Your ref:  
Our ref: 21/01753/F  
Please ask for: Miss Sandra Homcenko  
Direct dial: 01553 616824  
Direct fax: 01553 616652  
E-mail: borough.planning@west-norfolk.gov.uk

Details: **Removal of existing single storey lean-to, with construction of new two storey extension, and internal alterations to existing ground floor layout at rear of property. at 12 Oxborough Road Stoke Ferry King's Lynn Norfolk PE33 9TA**

Sections

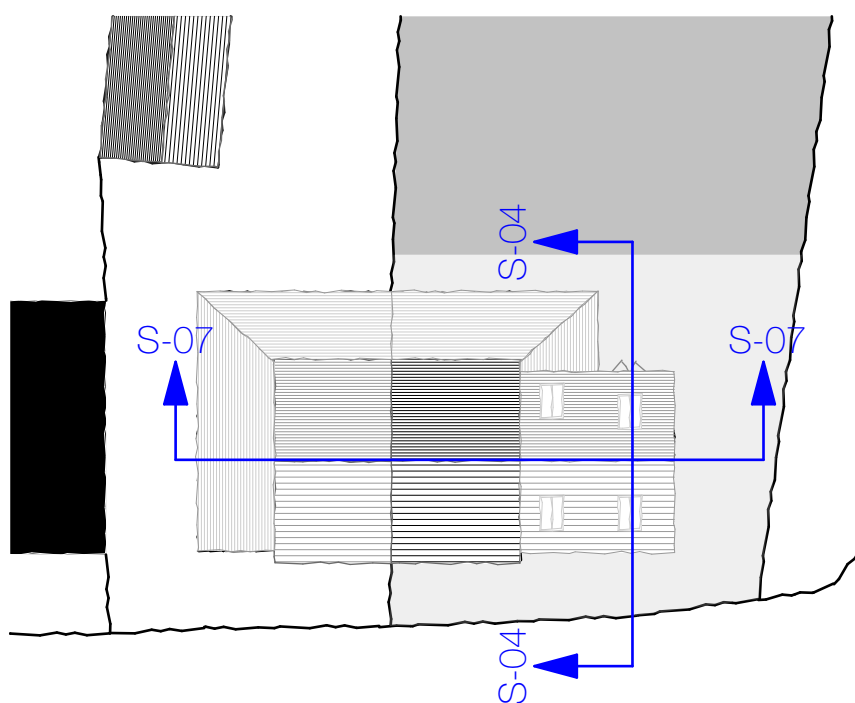
1. Please provide a plan showing correct position of proposed roof lights on the Floor plan
2. Although you have already provided existing and proposed Roof Plans, it appears that the Proposed Site plan is missing roof lights, please forward amended plan
3. Please provide four copies of a drawing, to a recognisable scale, showing a section through the new extension.
